From: Amanda Scholes on behalf of Planning.Responses
Sent: 01 June 2020 12:04
To: Planning Scanning
Subject: FW: *EXTERNAL: RE: BN/18/20/PL, Former Brooks Nursery

In terms of the proposals effect on the existing suds (surface water drainage system), I would like to make the following comments;

A	21.05.19	Bellmouth amended	HJS
REV. No.	DATE	DESCRIPTION	INITIALS
Client	 BARRATT HOMES		
Project	Brooks Nursery Barnham		
Title	Foul Outfall Rising Main Details		
Scale	1:250	Date	Sept '18
Checked	AMc	Drawn	AMc
Drawing No.	4482:510	Rev	A

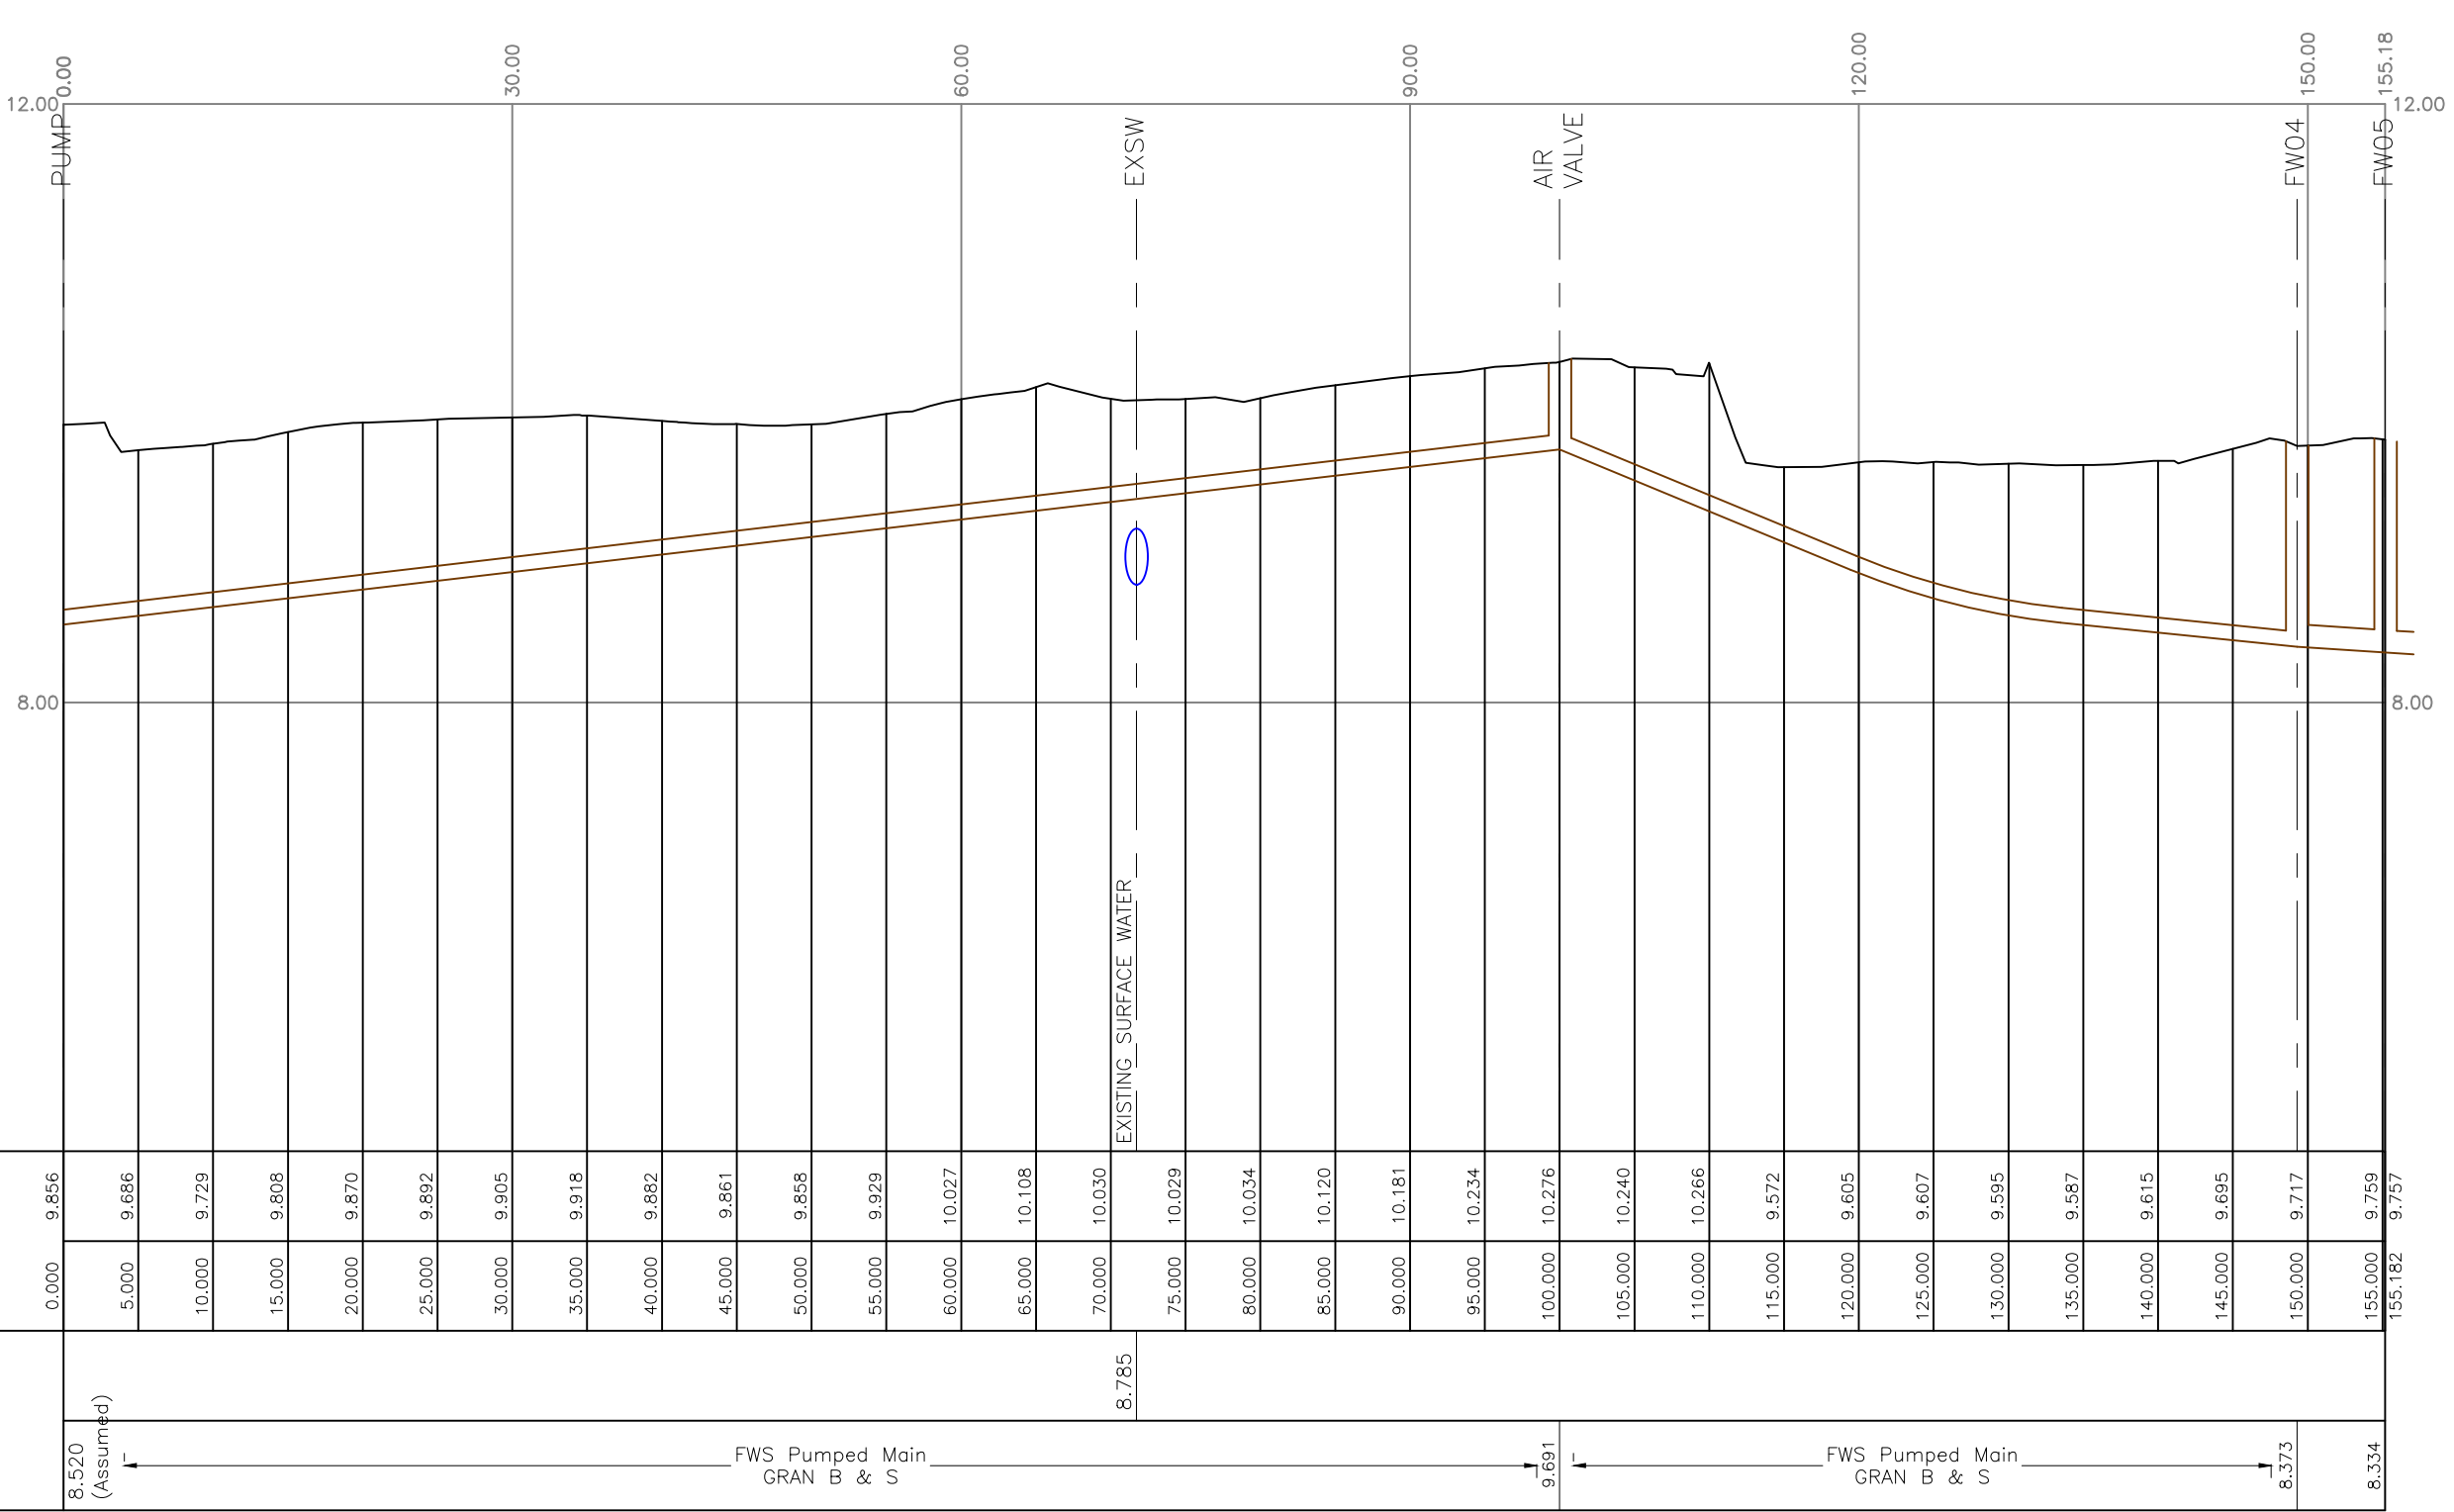
I will ask our engineer for the long section to incorporate the land drain requested

- a) The open channel/ditch in which the sewage treatment plant discharges into at present, before it connects into the suds pond, is proposed to be infilled.
The applicant will need to provide written confirmation with supporting calculations to prove that the storage for surface water within the suds system is not compromised as a result.
- b) Where the proposed rising crosses the incoming surface water outfall to the pond and the known land drain running parallel to the eastern boundary of the development, the applicant should provide a longitudinal section to prove no impact on these pipelines.

Finally, the long section requested was already shown on drawing no, 4482.510A , which I attach for reference along with the other engineers drawings which were agreed at the meeting

Section 104 Layout Phase 1

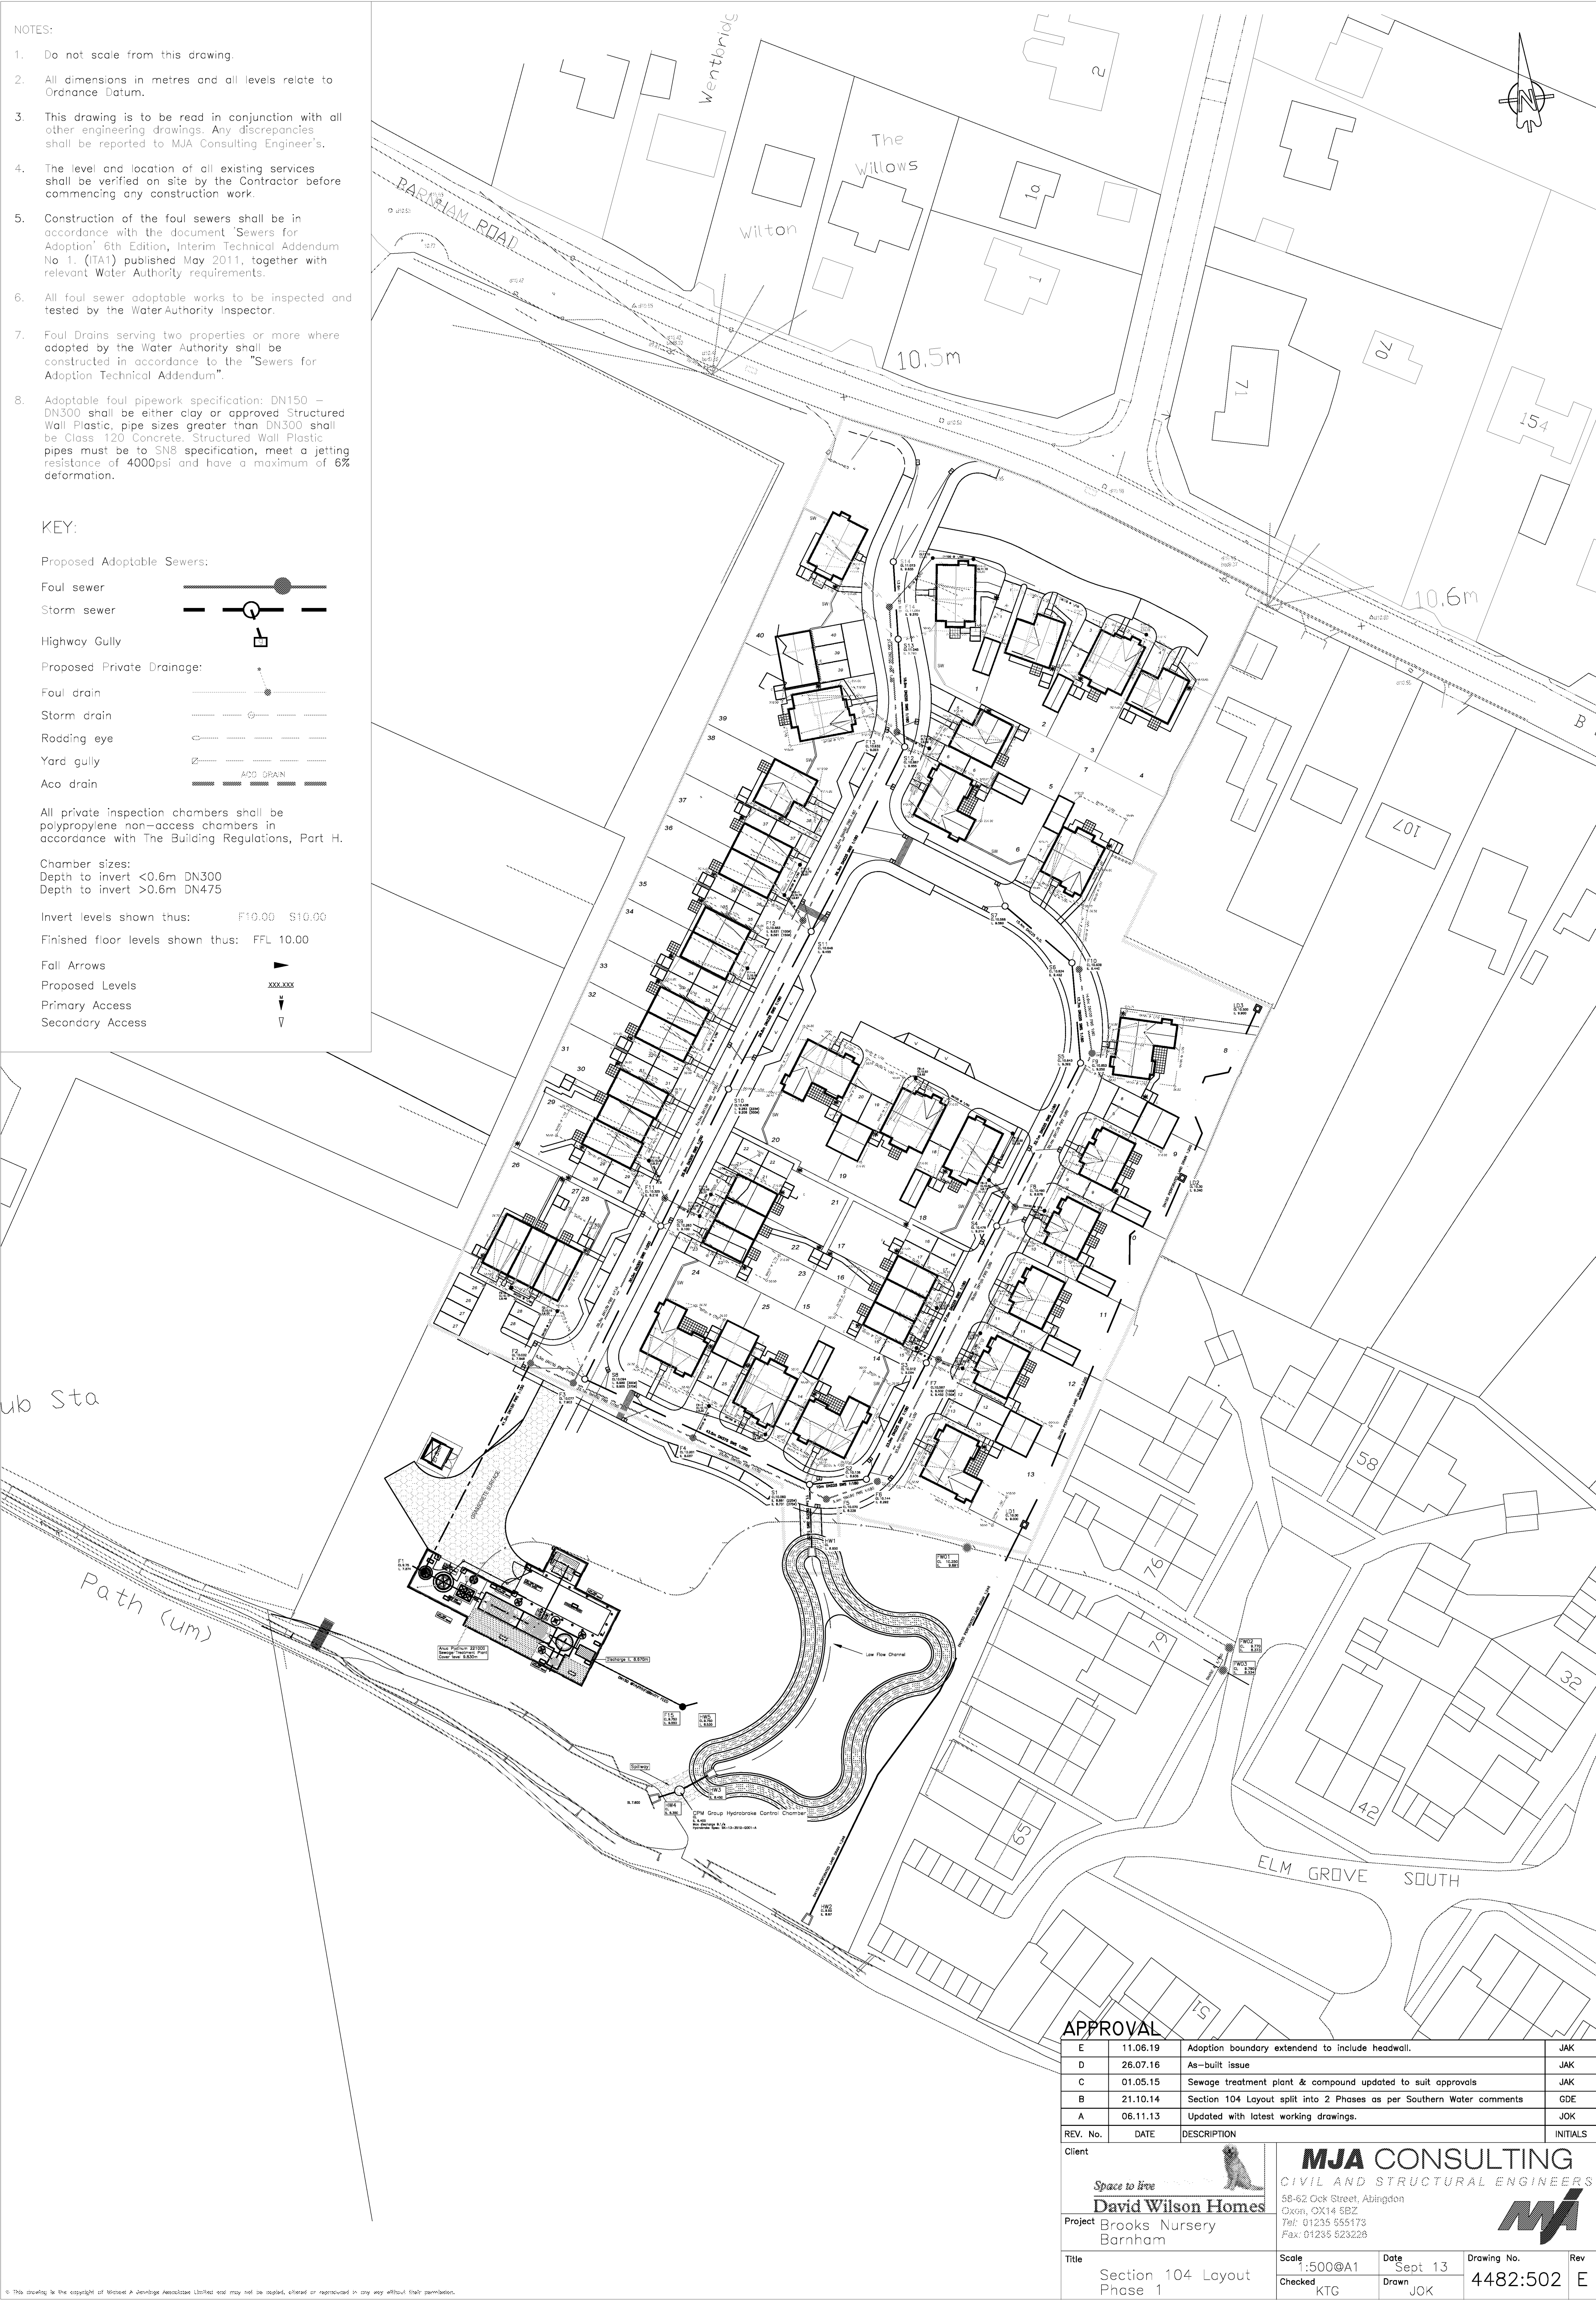
Just for clarity, is the effluent ditch to be retained or infilled. Your email suggests it will remain but the drawings show it to be filled. I have no objection either way.

- The small outfall ditch for the treatment plant was not part of and did not contribute to the overall volume within the surface water attenuation design, this was purely an outfall for the foul treatment plant. By not filling the ditch in would potentially create a dead stagnant spot for water, as this won't be part of the natural flow path. The original pond calculations are attached for clarity. Noted but calcs not included in email.
- The rising main section previously submitted was updated following discussion with Southern Water, however this was regarding the off-site connection and some manhole details. Nothing has changed regarding the rising main position over the existing surface water outfall pipe. The longitudinal section needs to show the land drain on the eastern boundary to make sure there is no clash with the rising main.

A meeting was held with Paul Cann and Rosemarie Dannatt , just before lockdown, and it was agreed to leave the existing ditch and not infill. This was due to ecological & wildlife benefits

The storage calculations for the surface water pond were also not required to be updated, as its current capacity allows for foul water storage too, which will be no longer required. We were simply asked to bund off the redundant incoming swale.
